**Addendum No. 1**

RE: Contract ID C203585

**Mecklenburg County (U-5008)**

SR-2975 (East Sugar Creek Road) Over NS/NCRR Crossing

APPROVED: <u>Steve Miller</u> DATE: <u>3/2/2015</u>			<h1 style="margin: 0;">PHASING</h1>
---	---	---	-------------------------------------

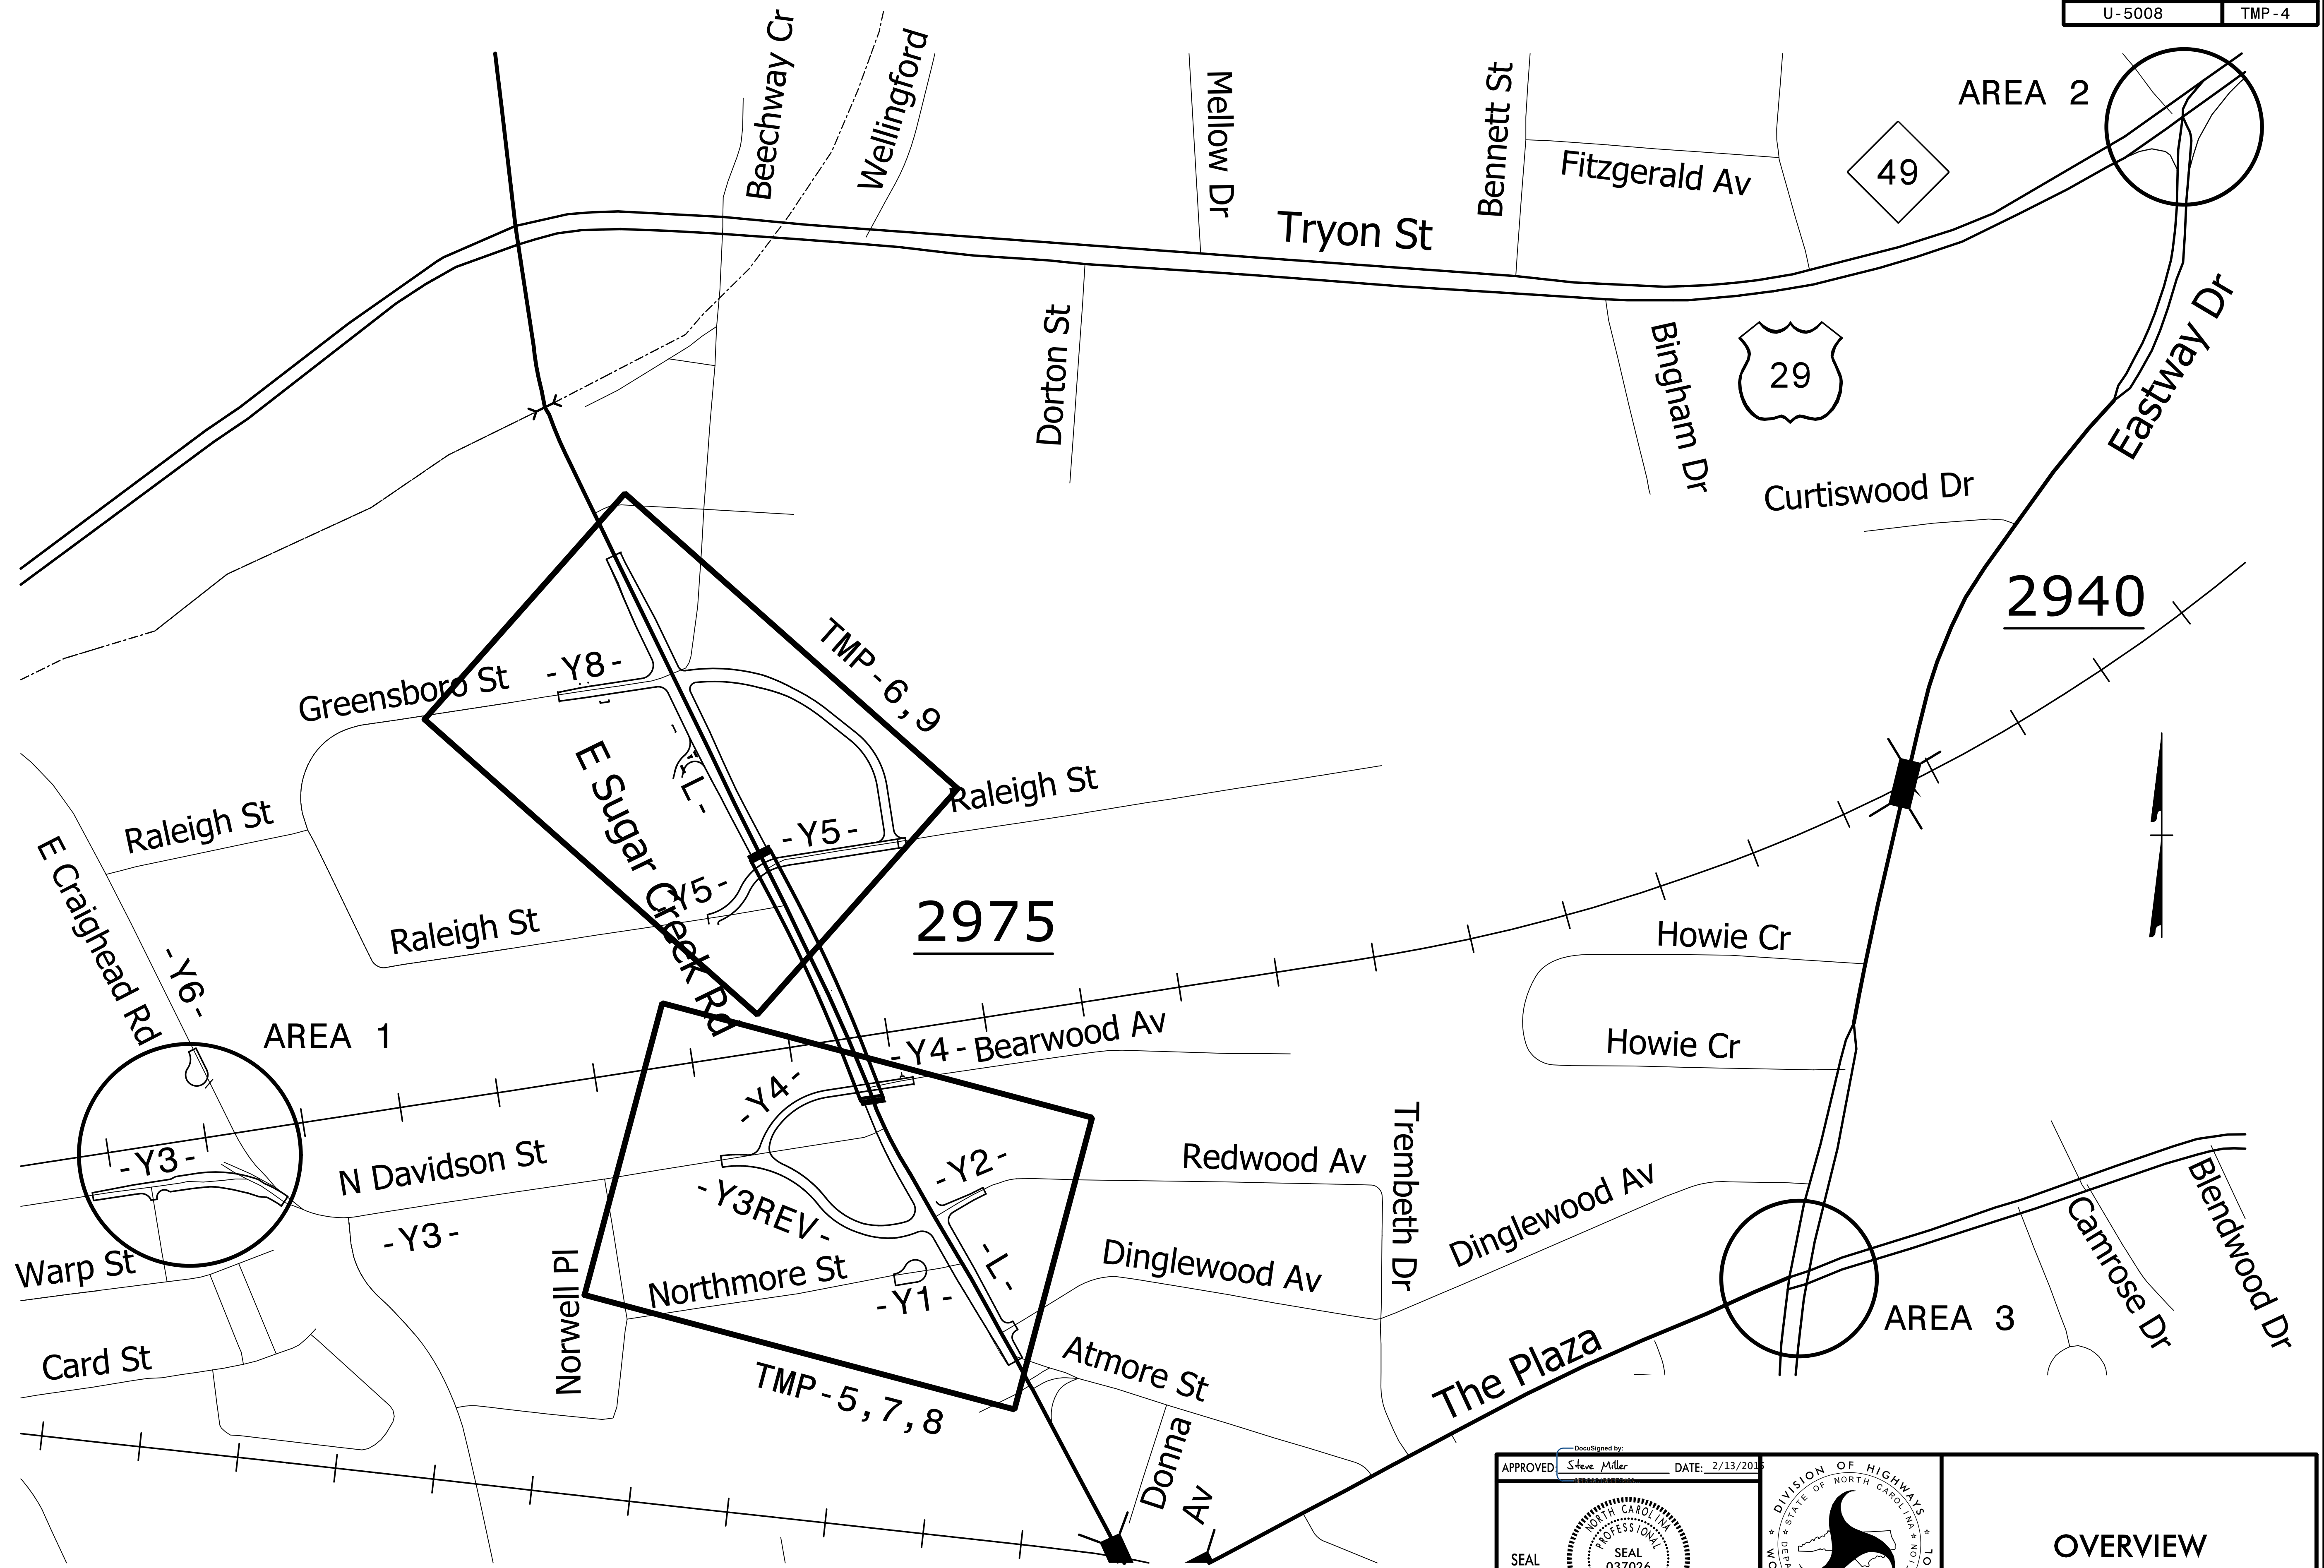
Sheet No.	Revisions
TMP-3	Date was removed inside the box under Phase I, Step 2 in the Phasing. Please void Sheet No. TMP-3 in your plans and staple the revised Sheet No. TMP-3 thereto.
